OXFORDSHIRE COUNTY COUNCIL'S RESPONSE TO CONSULTATION ON THE FOLLOWING DEVELOPMENT PROPOSAL

Application no: 23/01493/REM

Proposal: Reserved Matters Application including access, layout, landscaping and scale pursuant to outline planning permission 14/02121/OUT for internal primary and secondary streets along with the partial discharge of conditions 12 (Building for Life 12), 16 (means of vehicular access), 17 (means of pedestrian/cycle links) and 19 (detailed surface water drainage scheme) for Phase 1B

Location: Proposed Himley Village North West Bicester, Middleton Stoney Road, Bicester

1

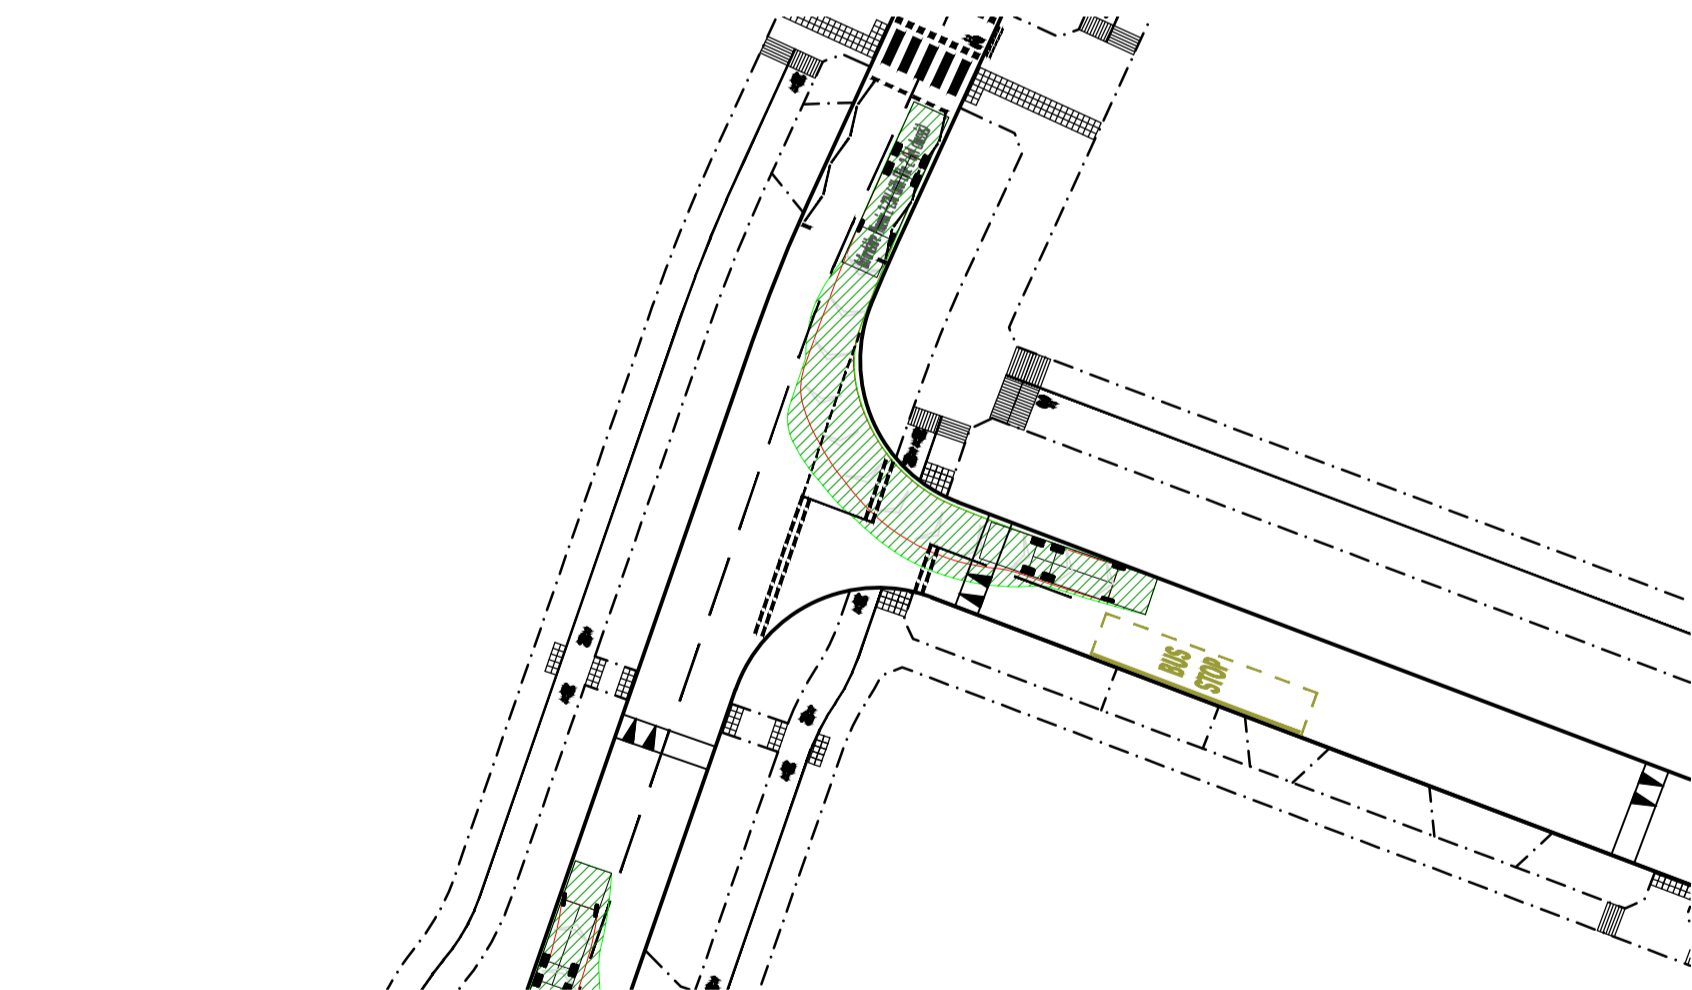
I previously explained that the temporary bus turning heads were not acceptable as it would require buses reversing over the raised cycle crossings. After discussions with the applicant, it has been agreed that the raised cycle crossings at the northern end of the Spine Road North - South and at the eastern end of the Spine Road East - West will be implemented when Oxfordshire County Council have confirmed that the requirement for the use of the temporary bus turning heads has ceased.

In addition, the raised crossings at the western end of the strategic secondary streets will be implemented when these roads connect to Phase 3 and Oxfordshire County Council have confirmed that the temporary turning heads are no longer required. Insets on the Engineering Layout Sheets 1 to 4 include the layout of all the temporary turning head as well as the agreed final layout.

In accordance with the approved Phase 1B Engineering Layout Sheets 1 to 4 (dwg nos 27141-HYD-1B-XX-DR-C-2200/P09, 27141-HYD-1B-XX-DR-C-2201/P10, 27141-HYD-1B-XX-DR-C-2202/P10, 27141-HYD-1B-XX-DR-C-2203/P09) works associated with the temporary bus turning heads shall be constructed and remain in place until Oxfordshire County Council have confirmed that the temporary turning heads are no longer required. The final road layout as shown on the approved plans, including raised tables and all road markings, shall be completed within 6 months of the final use of the temporary turning heads unless otherwise agreed in writing with the Local Planning Authority.
